Response to Agency & Public Submissions

Issue	Details	Response
City of Sydney		
SEPP 1 Objection – height and floor space	<p>In accordance with State Environmental Planning Policy (State Significant Precincts) 2005 (SEPP SSP), the site is located in the Business Zone – Commercial Core zone and prescribes a maximum height of 18 storeys and a floor space ratio (FSR) of 7:1.</p> <p>The amended scheme presented in the RTS proposes a height of 18 storeys with a new mezzanine level and a FSR of 7.85:1. The RTS suggests that the site is eligible for bonus floor space by virtue of its location within an 'equivalent' zone to those listed under Division 3 of the State Environmental Planning Policy (Affordable Rental Housing) 2009 (SEPP ARH).</p> <p>The City maintains the view that the provisions and floor space bonuses of SEPP ARH are not applicable for the development. As previously stated in our correspondence dated 12 March 2019, the site is located in the Business Zone - Commercial Core which is not a land use that is listed under Clause 26 of State Environmental Planning Policy (Affordable Rental Housing) 2009.</p> <p>In light of the above, the proposal is an overdevelopment of the sit

GIBBONS ST 18029:  
FACADE CONCEPT:

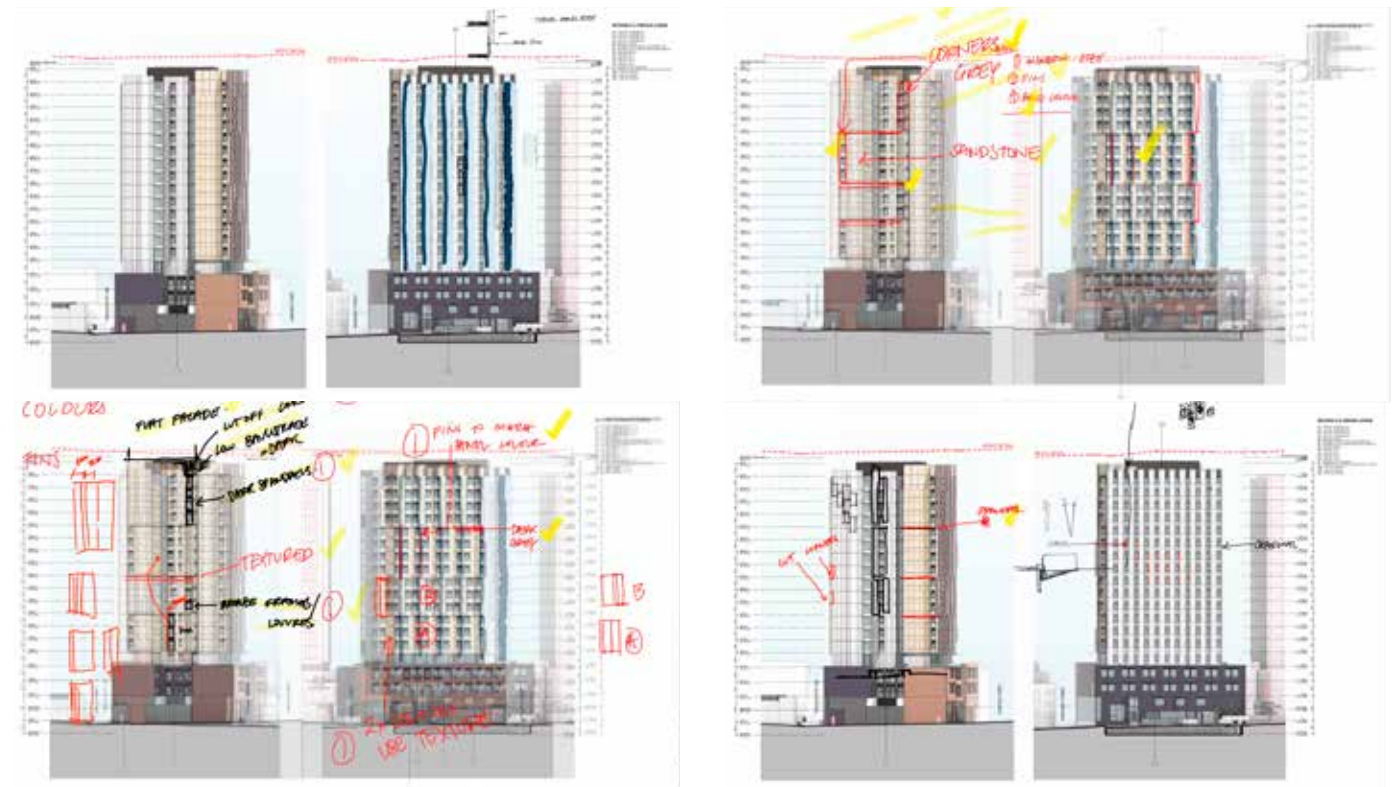
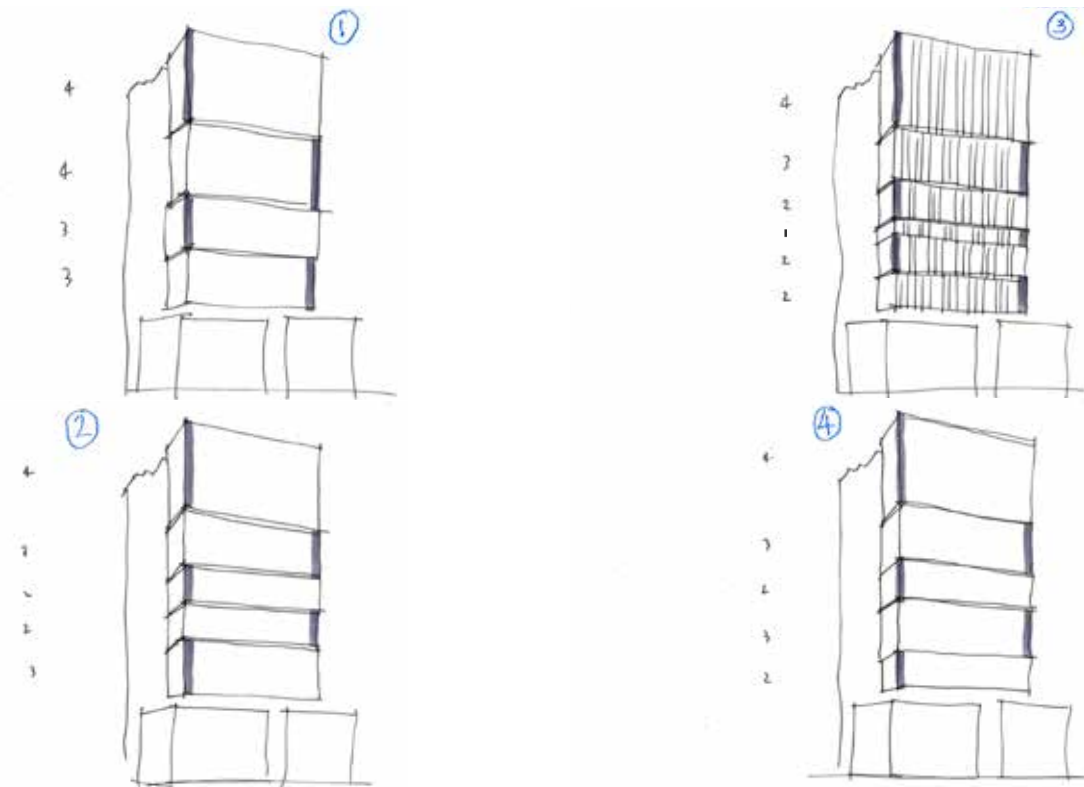
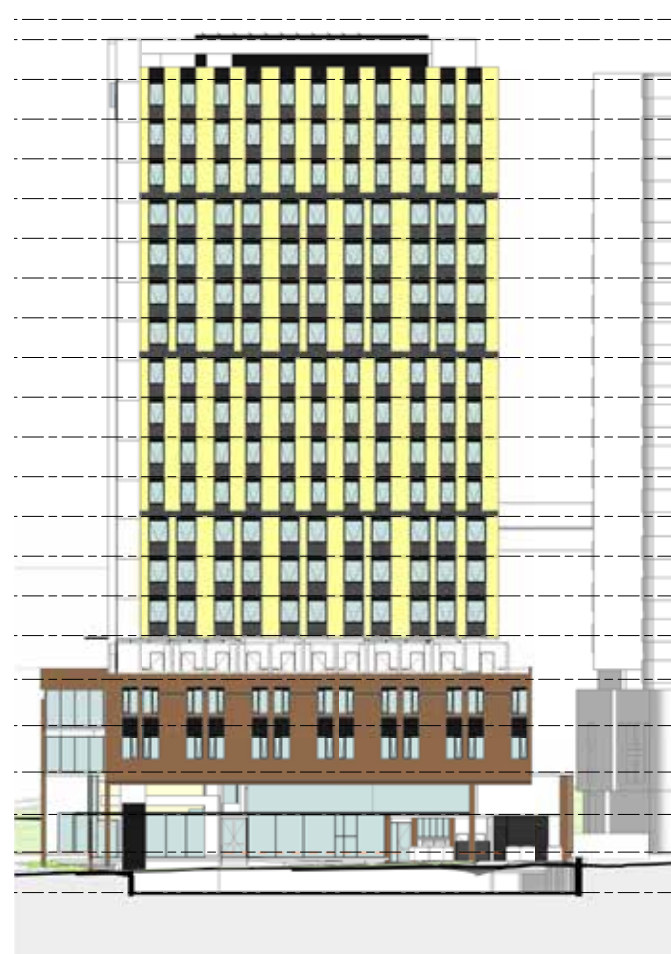
Urban Design	<p><i>Built form and height</i></p> <ul style="list-style-type: none"> It is reiterated that significant consideration should be made on achieving an appropriate transition between the built form of the approved 18 storey development to the north (11 Gibbons Street) and the existing 5 storey development to the south at Margaret Street. This can be alleviated through improving the building expression of the development, as detailed below. Having regard to the mezzanine level mentioned above, the proposal presents a technical street frontage height of 4 storeys and is inconsistent with the Section 4.2 – Design Principles: High Rise Development Portions of the Redfern Centre Urban Design Guidelines (RCUDG). The proposed height of 14.85m for the podium is approximately double that anticipated by the RCUDG, which prescribes a "strong base of 2-3 storey or 6.5-7.5m that responds to the human scale". The RCUDG assumes that the podiums are built to the boundaries and only setback to Gibbons and Marion Streets and William Lane to provide footpath widening. However, the proposed podium does not extend to the Margaret Street boundary. There is a minimum 870mm setback to contribute more space to the footpath, but not a footpath widening, with a varying setback to Margaret Street. This approach of not building parallel to Margaret Street fails to 	<p><i>Built Form</i></p> <ul style="list-style-type: none"> Building expression has been improved as detailed below The mezzanine has been deleted and the proposal presents a 3 storey podium. As detailed in the main report and the Supplementary Design Report (Appendix C), podium height is consistent with all other approved podium heights along Gibbons Street under the same controls. The podium has also been redesigned to provide a more consistent street edge to Margaret Street and provide a greater delineation between the podium and the tower on this façade and to improve the human scale of the podium.

Issue	Details	Response
	<ul style="list-style-type: none"> Having regard to the other matters detailed above, further consideration should be made to improving the articulation of the building. This can be achieved through meaningful changes to certain façade elements to better integrate with neighbouring buildings and surrounding context. The City provides an extract of the east elevation (Gibbons Street) superimposed with the approved elevation of 11 Gibbons Street in Attachment A. To summarise, the building expression of the tower can be improved through the simplification of the horizontal elements into 3 evenly distributed parts. It is recommended that the shadow line between the tower and podium be maintained to break up the mass of the overall building. It is also recommended that the proposed podium be amended to match the podium height of 11 Gibbons Street and 'step up' to the corner of Gibbons Street and 'step down' along Margaret Street to correlate with the 2 to 3 storey scale to the south of the site. To this effect, the building expressions would be greatly improved and would positively responds to its context. Further, the RTS includes reference to "patterned precast panels". However, there is no sample of this indicated in the materials board. To understand the proposed expression of the building, it is recommended that an example or physical sample of the precast pattern be provided. Clarification is also sought on whether there is another indicative plan that is missing from the RTS set of architectural drawings that illustrate the different façade treatments for each elevation. <p><i>Signage</i></p> <p>The proposed top of building signage creates bulk and visual clutter. It is out of character with the adjacent low scale area to the south, nor are there any projecting wall signs at the top of the building within the Redfern-Waterloo Authority land to the north. A smaller projecting wall sign is proposed above the awning on Gibbons Street. The sign is not supported and would be more in keeping with signage in this area as a wall sign.</p>	<ul style="list-style-type: none"> Podium height has been amended to match adjoining building heights as suggested by the City – refer to the main report. Refer to Supplementary Design Report at Appendix C for materials and finishes <p><i>Signage</i></p> <p>The proposed top of building signage is not a projecting wall sign and has been designed in accordance with the requirements of Council's DCP. The smaller projecting wall sign at the entrance is deleted in favor of a wall sign on the northern façade of the building and a small awing sign. Refer to discussion in the main report and revised details in Appendix B.</p>

**Figure 19 Recently Proposed Level 4 Mitigation**

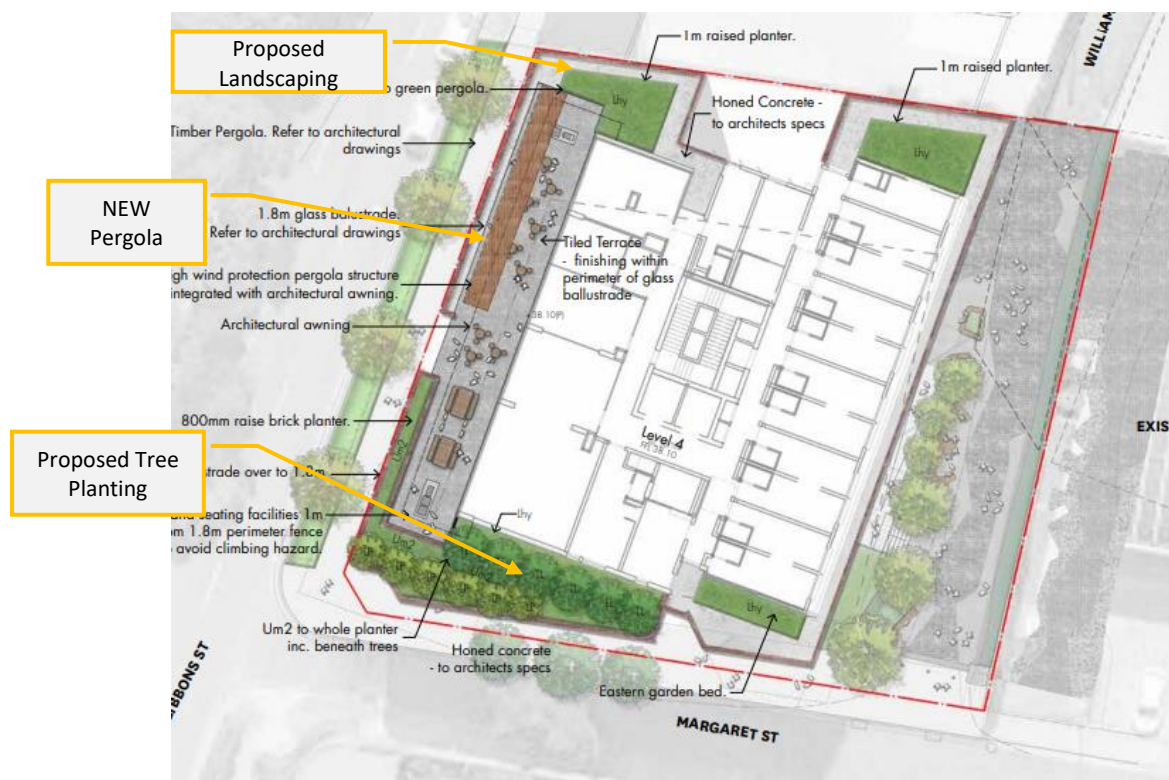
Issue	Details	Response
Wind Impacts	<p>The RTS and Environmental Wind Tunnel Test Report, prepared by SLR, provides wind tunnel test results for the amended development building proposal only. The testing omitted all wind mitigation recommendations such as landscaping, street and podium trees, overhead pergolas and awnings and perimeter windbreaks.</p> <p>The Report relies on the existing mature street trees on Gibbons Street to ameliorate significant wind speeds. However, to facilitate construction, all existing street trees on Gibbons Street are proposed for removal and replanted with new trees.</p> <p>Further, the Report suggests that the wind conditions along Margaret Street are generally worse for a compliant scheme. This is unexpected as the compliant scheme has a 4m upper level setback from the street frontage height whilst the proposed development presents, in part, a 1.5m setback from the street frontage height to Margaret Street. There is a correlation with setbacks to towers and wind impacts at ground level. Typically, the greater the tower setback from the podium, the more effective the amelioration of the wind at ground level. It is expected that a podium disrupts the down draft and disperses the wind before it impacts the ground level.</p> <p>Having regard to the above, the Report recommendations are not adequately justified and flawed. It is recommended that the Department commission a peer review of the Wind Report and the wind impacts. The revised wind analysis remains insufficient and the considerable wind impacts resulted from the proposal is unacceptable and the City's initial concerns remain outstanding.</p>	<p>As discussed above, activation is improved by the incorporation of a small coffee retail outlet.</p> <p>An updated report is provided (Appendix K) which includes consideration of all mitigation measures and demonstrates their significant ameliorative effects.</p> <p>It is proposed to improve street tree planning on Gibbons Street, replacing three extensively pruned trees (pruned due to the power lines) with advanced plantings of four new trees. It is also proposed to underground existing overhead power lines, enabling better long-term tree growth for the new replacement trees than the existing trees, and therefore ultimately resulting in better wind amelioration impacts than could be achieved by the existing trees.</p> <p>As discussed in the main report, the design of the podium has been amended to achieve a greater setback between the tower and the podium, with average setbacks exceeding 4 metres, therefore disrupting any down draft impacts to the same extent as any other building expected by the controls. Once ameliorative measures are accounted for, peak annual wind gusts on Margaret Street are expected to be between 10.0 m/s and 16.0m/s, suitable for walking comfort and in most cases, also suitable for standing / waiting / window shopping.</p>

MID-WINTER SOLAR ACCESS - GREEN SPACES

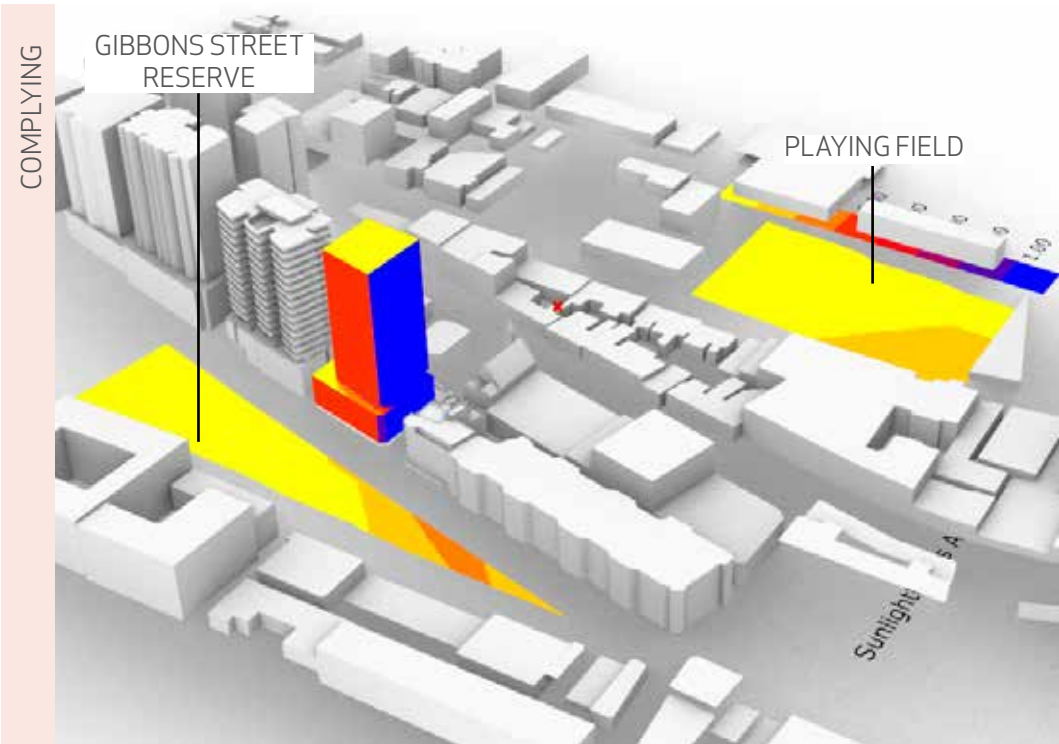
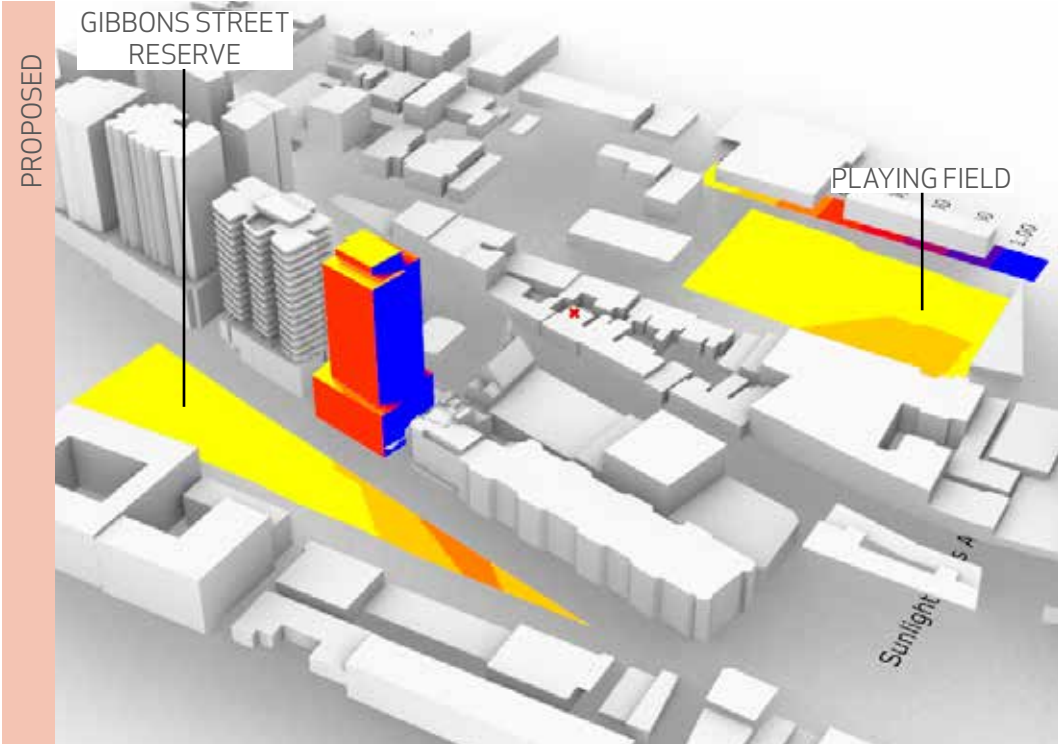
Overshadowing	<p>The RTS and the submitted shadow diagrams reason that the additional overshadowing resulted from the proposed development is acceptable given the extent of impact is relative to the shadows cast by a compliant envelope.</p> <p>Notwithstanding the above and discussed elsewhere in this report, the proposal results in other negative environmental impacts. Therefore, the justification for the additional overshadowing is inadequate and to permit the development and other associated environmental impacts is unacceptable.</p>	<p>The proposal does not result in any additional overshadowing beyond that expected by the controls which apply to the site and therefore must be considered to be reasonable and acceptable.</p>
Public Art	<p>Whilst the RTS acknowledges that a condition of consent is accepted for a detailed public art plan to be submitted prior to issue of a Construction Certificate, The City encourages that the future public art plan provide substantial detail of the artwork's relationship with its context and address how wind impacts in the TSL would impact the long term viability of the proposed suspended artwork in this location as well as the safety of pedestrians who traverse underneath. The final detailed public art plan must be in accordance with the City of Sydney Guidelines for Public Art in Private Developments</p>	<p>Agreed. This can be conditioned.</p>
